Final Drainage Report

I68 Training Facility

December 6, 2024

PCD File No. PPR2440

Channel C1 (Central) - 100yr = 63.9 cfs

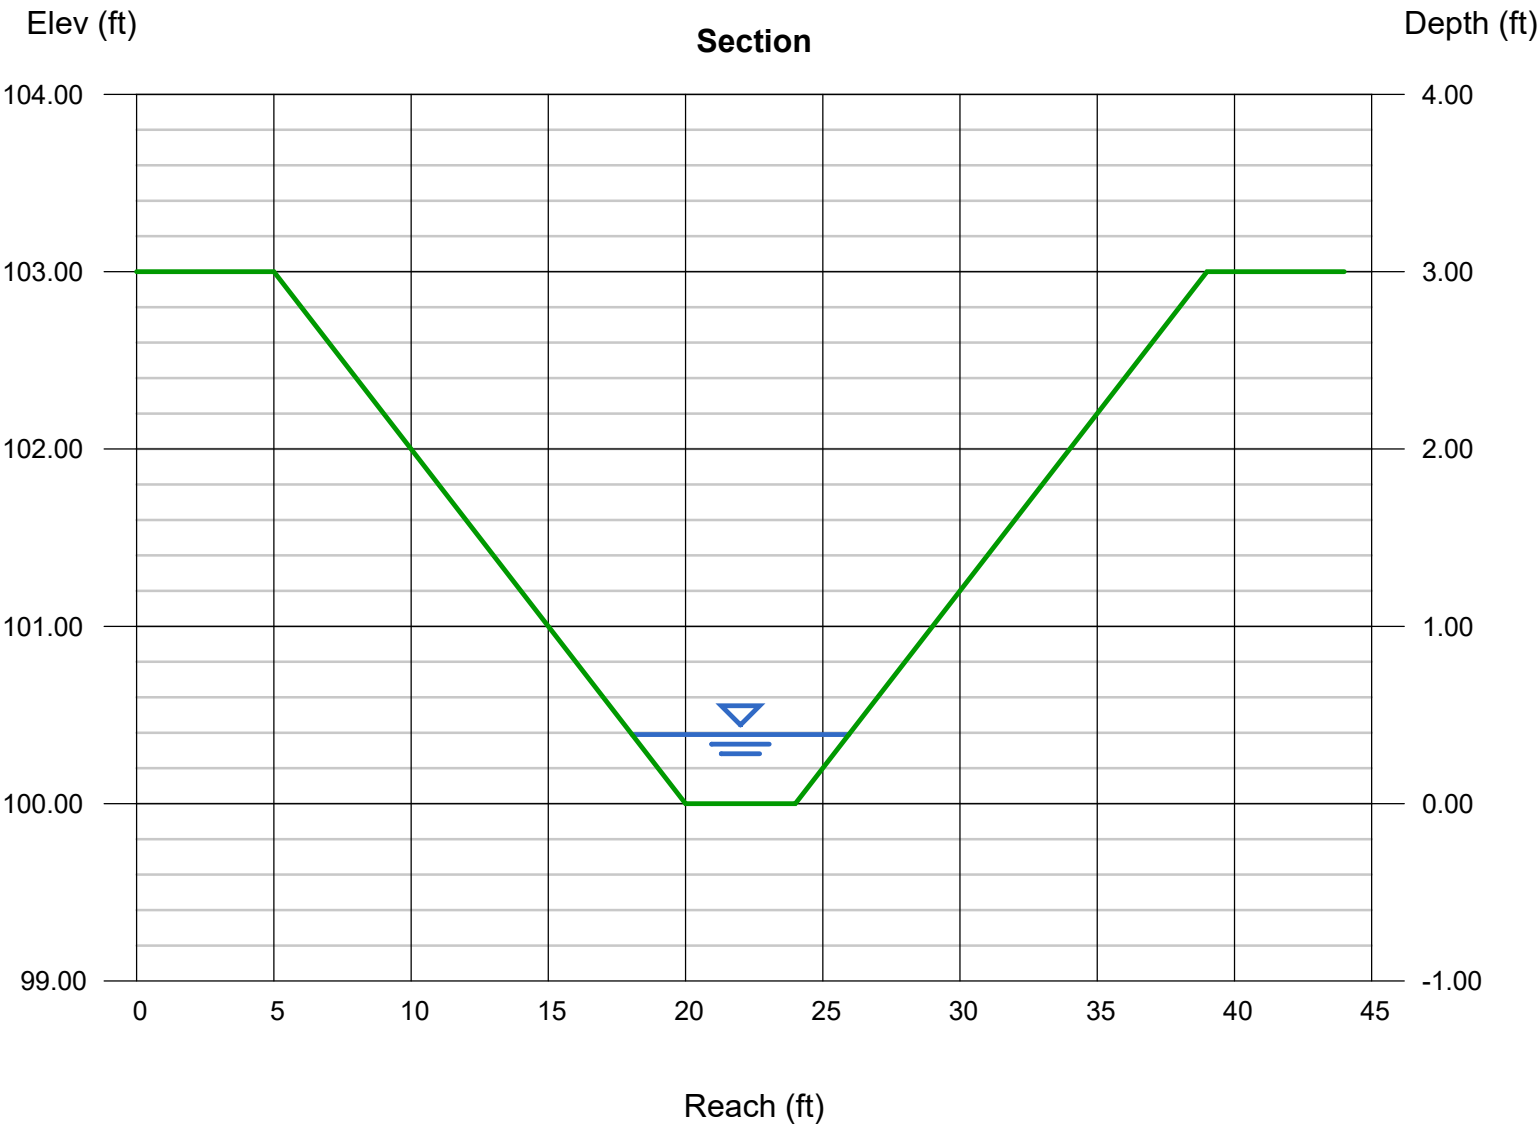
See note in calcs for required channel C1 erosion protection

DRAINAGE REPORT

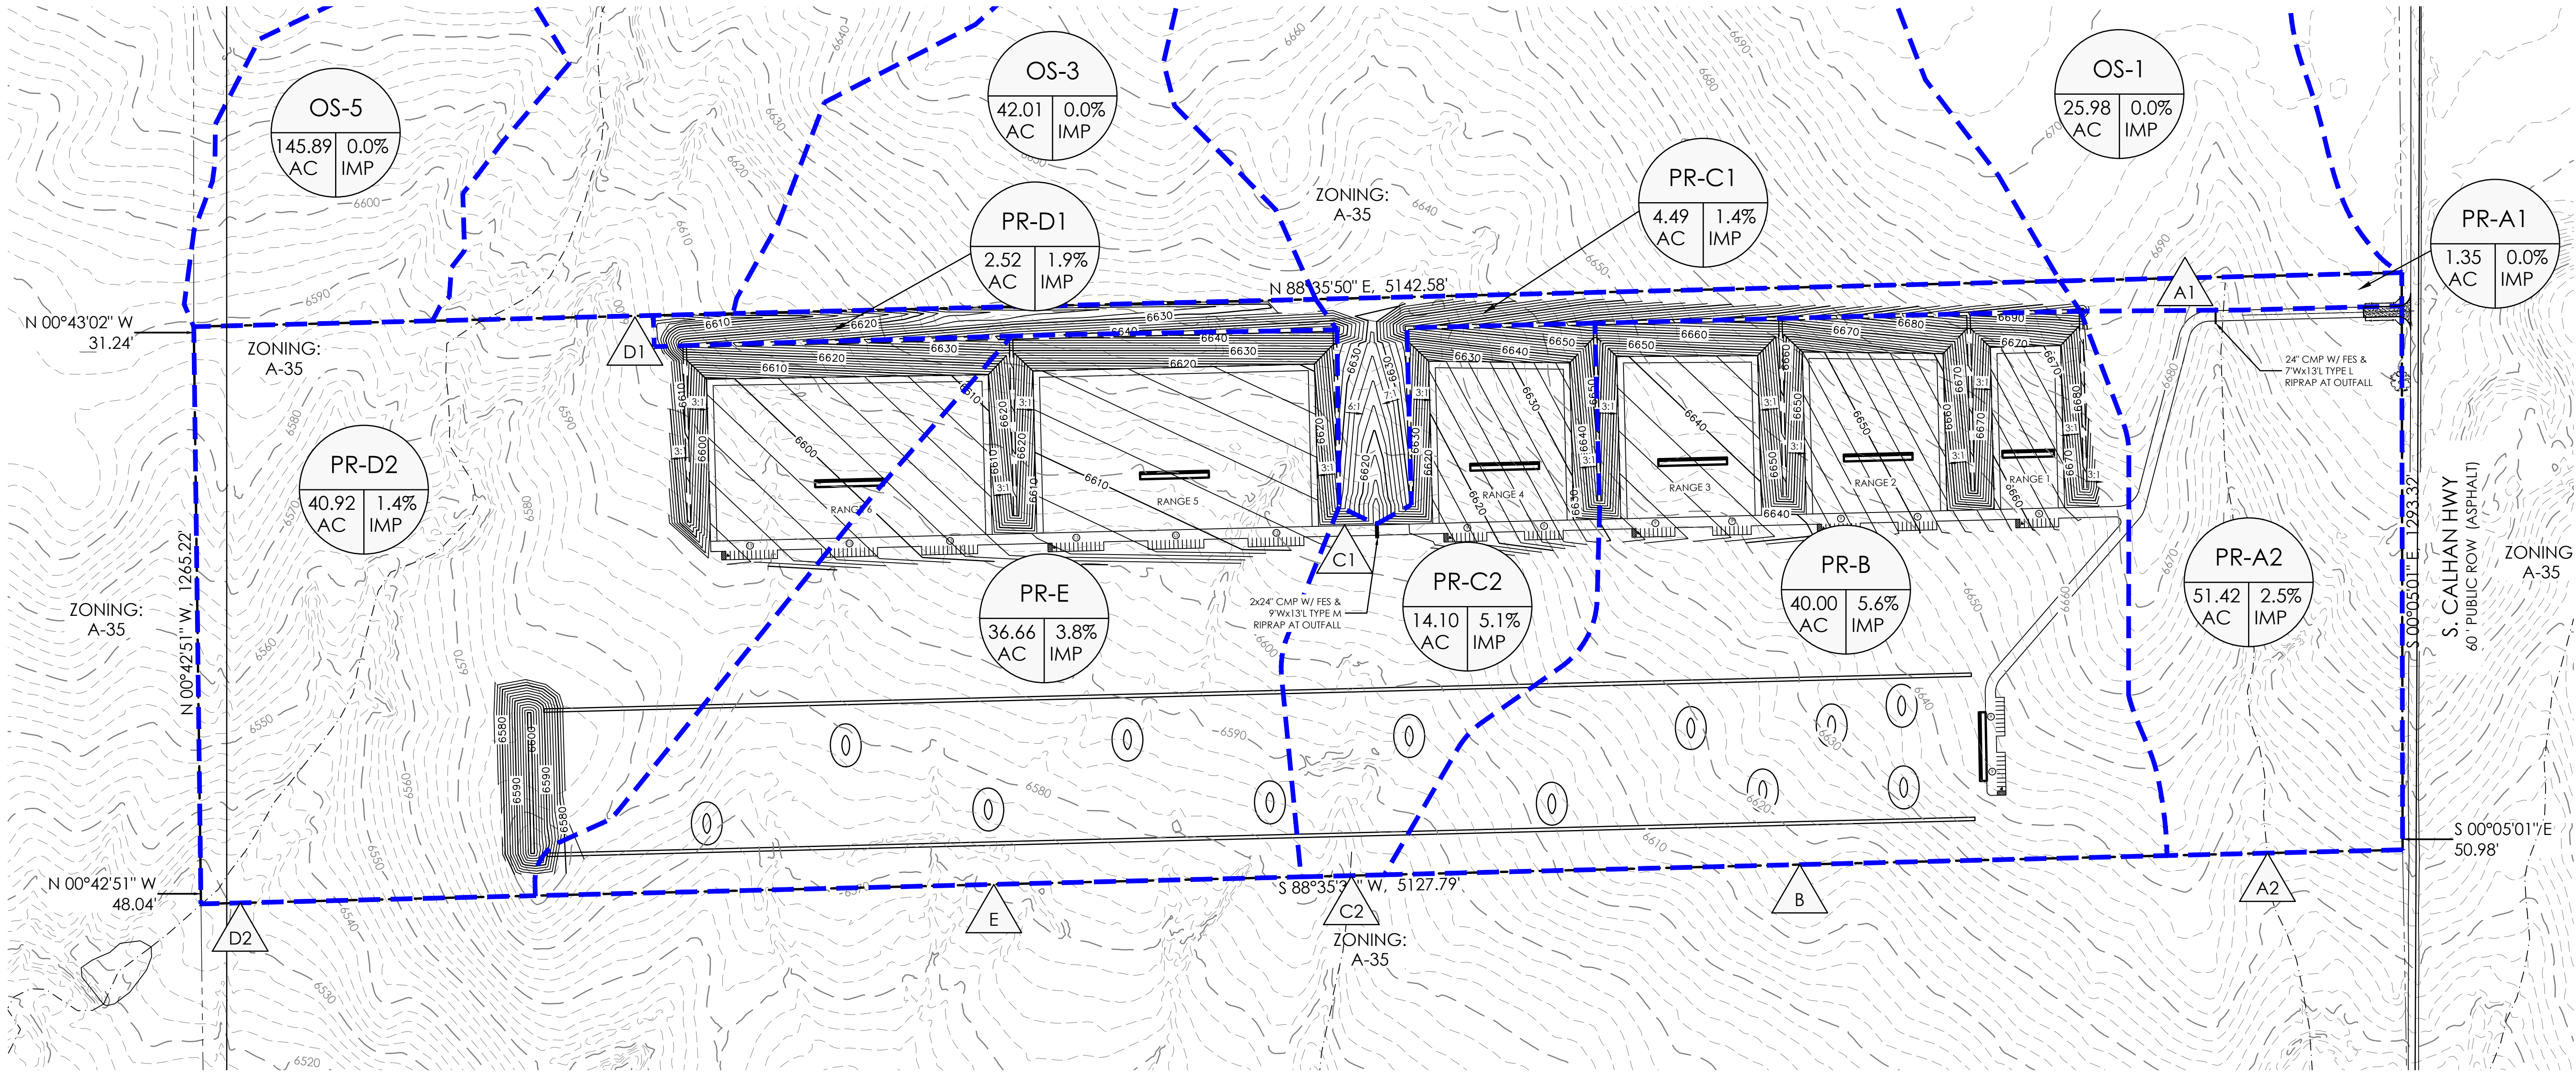
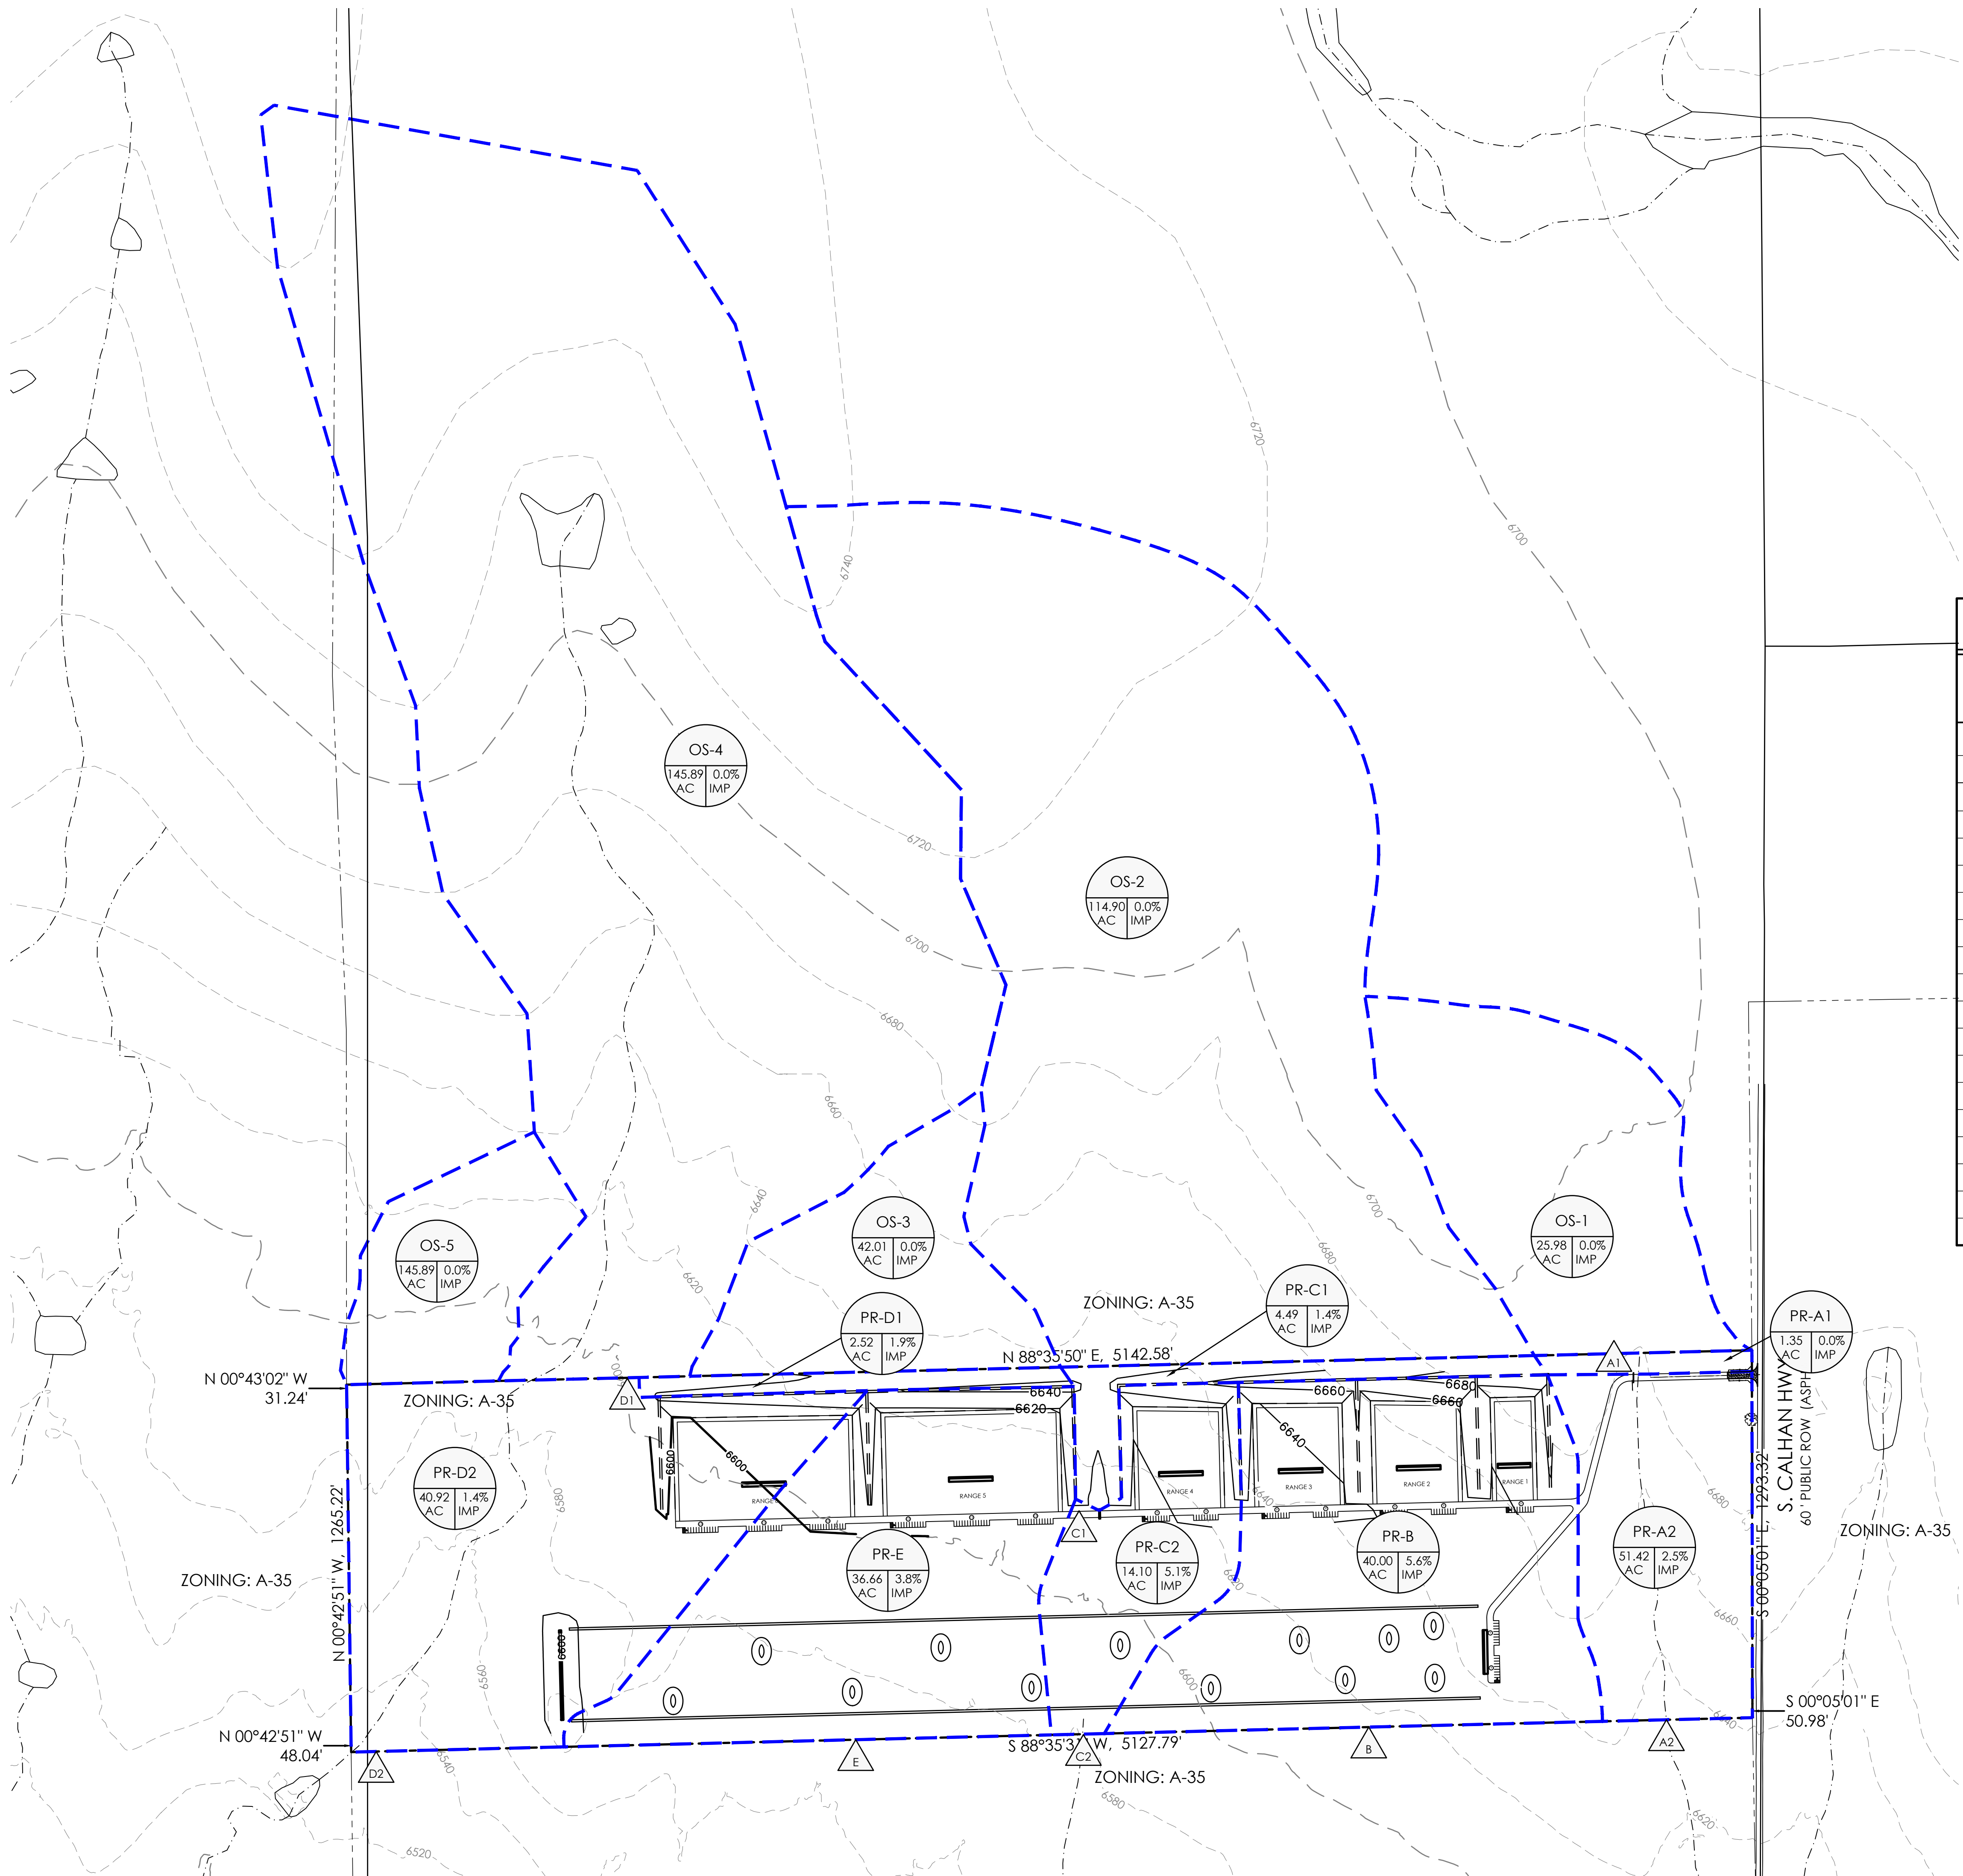
Doesn't match drainage map

Doesn't match drainage map
